SUBMISSION OF OBJECTION

Hunter Valley Operations North – Carrington West Wing Extension
DA 450 – 10 – 2003 MOD 3

APPENDIX 4  
CONCEPTUAL GROUNDWATER BARRIER WALL

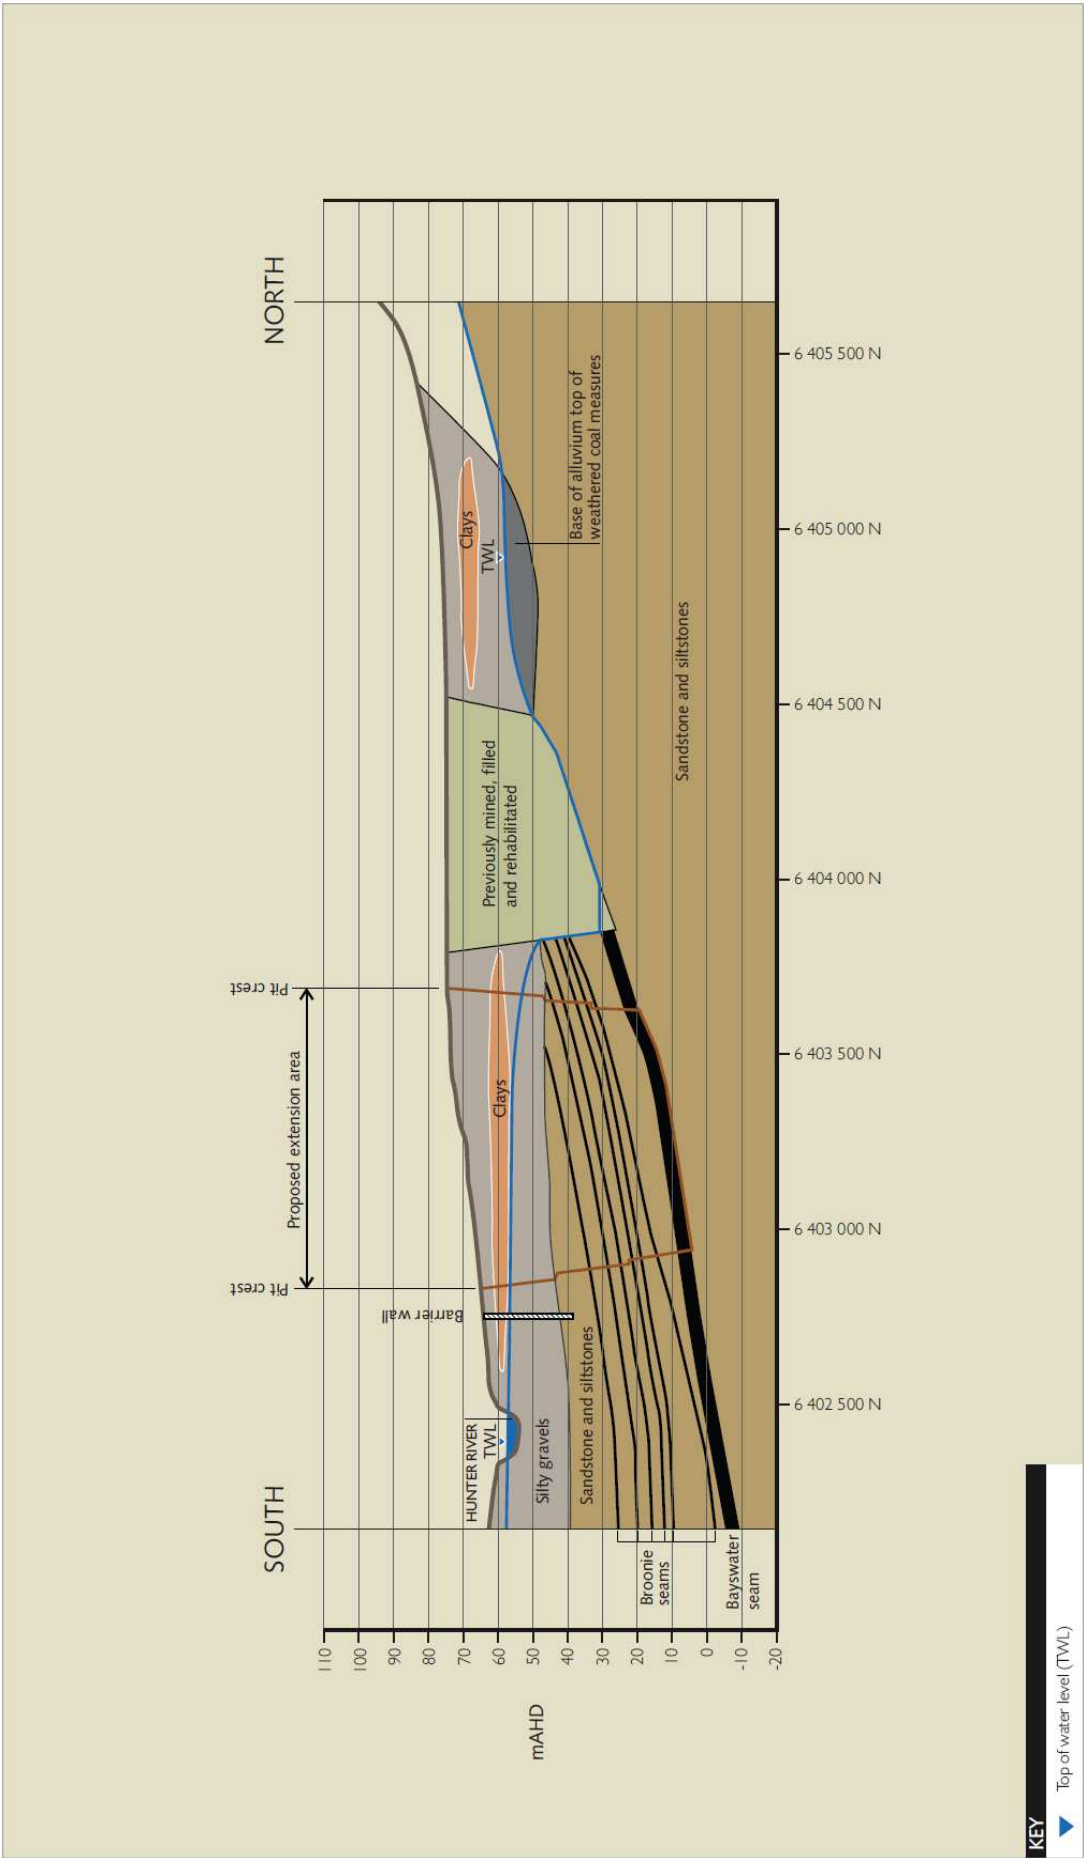
The modeled loss of base flows drops from 0.2ML/day (or 3.65GL over 50 years) to 0.05ML/day with the proposed construction of a bentonite barrier wall. There is no detailed description of the proposed wall including construction, composition, permeability or a detailed assessment of the performance of the existing wall recently constructed. There is no indication of performance criteria or risk assessment of the barrier failing.

Measures to mitigate failure or compromise of the barrier to prevent larger base flow losses to the Hunter River have not been identified.

There is no technical information about the barrier. Its performance has been inadequately explained as to how it is expected to provide the required protection. Rivers SOS contends that its success has been grossly overestimated. Given the important role it is to perform this omission cannot be allowed to stand. The absence of any performance assessment for the existing barrier and performance criteria for the future wall must be addressed. The likely impact to the Hunter River could have been disguised by the failure to release data to demonstrate its reliability in preventing seepage from the river into mine workings or spoil coming either under or around the barrier.
